Burrah Park – Badgerys Creek

Riparian Assessment – Response to Submissions

Project Name:	Burrah Park (1953-2109 Elizabeth Drive, Badgerys Creek)
Project Number:	24SYD8475X
Project Manager:	Courtney Blick

Figure 10: Riparian encroachment and offsets

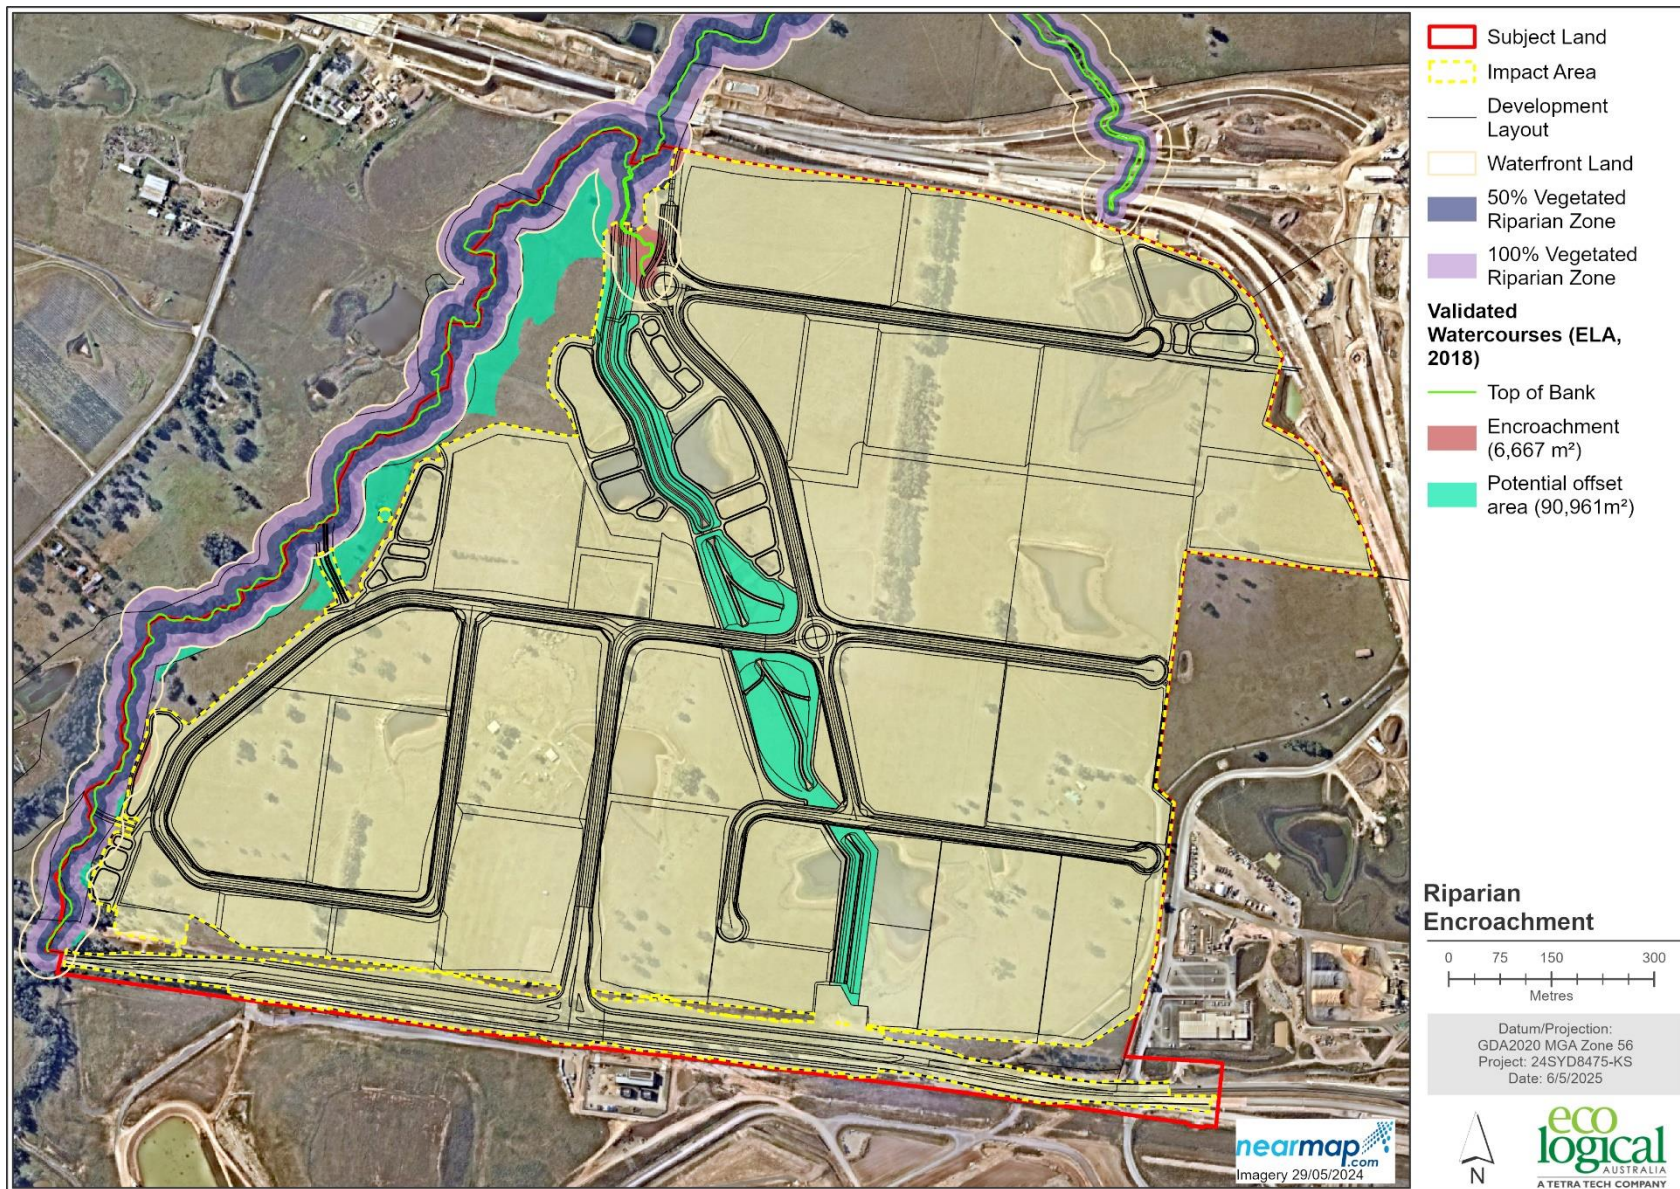
RTS Advice	Response
1.1 Recommendation – pre-determination The Department of Planning, Housing and Infrastructure (DPHI) should seek from the proponent: • A review of the proposed infrastructure footprint and layout to meet watercourse buffer requirements as defined in the Guidelines for Controlled Activities on Waterfront Land. • A plan which clearly identifies the top of bank for on-site watercourses and the associated inner and outer riparian zones and any proposed encroachments or offsets. • Confirmation of the riparian corridor and Vegetation Management Plan planting extent along the second order watercourse in the centre of the site. Explanation: The mapped 2nd order stream within the centre of the site is mapped as an offset area as opposed to a watercourse as the proponent's assessment considers this watercourse did not meet the definition of a river under the <i>Water Management Act 2000</i>. The condition of the watercourse has been significantly modified by agricultural activities but some channelisation is clearly apparent on our imagery despite it being distorted due to current land use. While Water Group can accept the re-alignment on merit, it is still recommended that the riparian corridor width for a second order stream outlined in the guideline is applied. An updated encroachment/offset map is requested to demonstrate the channel and associated riparian area is generally in accordance with the <i>Guidelines for Controlled Activities</i> for the second order watercourse. The VMP provided indicates that the second order watercourse will be fully revegetated. Clarification is required on the width of the planting areas. This information is requested to aid in identifying and confirming riparian corridor widths are consistent with the guidelines. Water Group recommends that the full riparian corridor as prescribed by the guidelines is applied to all 3rd order and higher watercourses with restricted use of the averaging rule. This is important in order to maintain consistency with other developments assessed in the vicinity. Provision of a full corridor has mostly been achieved for Oaky and Cosgrove Creeks which are 3rd order and 4th order watercourses respectively, with the exception of Basin F being within the Oaky Creek riparian zone. It is recommended that this basin is removed from the riparian area and relocated outside of the designated riparian corridor accordingly.	The encroachments and offset map has been updated to demonstrate general consistency with the Guidelines. The Vegetation Management Plan (VMP) applies to an average 20 m wide corridor around the central core trunk drainage alignment, aligned with the offsets map. The proposal provides more offset area than is required by the encroachments into the outer 50% VRZ (Figure 10). Encroachments into Oaky Creek (3rd order) are proposed, in order to facilitate stormwater basins in accordance with Sydney Water requirements. Specifically, Basin F is located in the outer VRZ and therefore encroaching on the riparian corridor. Use of the averaging rule has been applied in this instance, with offsets exceeding 10 times the area of encroachments under the proposal. Offsets will be managed and revegetated under a VMP. While this impact is unavoidable, excess offsets are provided contiguous with Oaky and Cosgroves Creeks.

No development is proposed within the inner 50% VRZ (Figure 10). Potential offset areas, which are also associated with a VMP, are available in the study area at more than 10 times the encroachment area. A total of 37,790 m² of offsetting through revegetation is proposed.

The proposal has been amended to achieve improved consistency with the Guidelines, avoiding realignment the validated extent of reach 2A and proposing a naturalised trunk drainage path for the remainder of reach 2A. This includes average 20 m wide corridor, to be managed under a Vegetation Management Plan (VMP) and improving the condition from its current state as an overland flow path. Road crossings are proposed on the trunk drainage channel at several points, consistent with the Guidelines. Areas of encroachment and offsets have also been considered within the central trunk drainage channel, and are aligned with the Guidelines for 2nd Order watercourses (Figure 10).
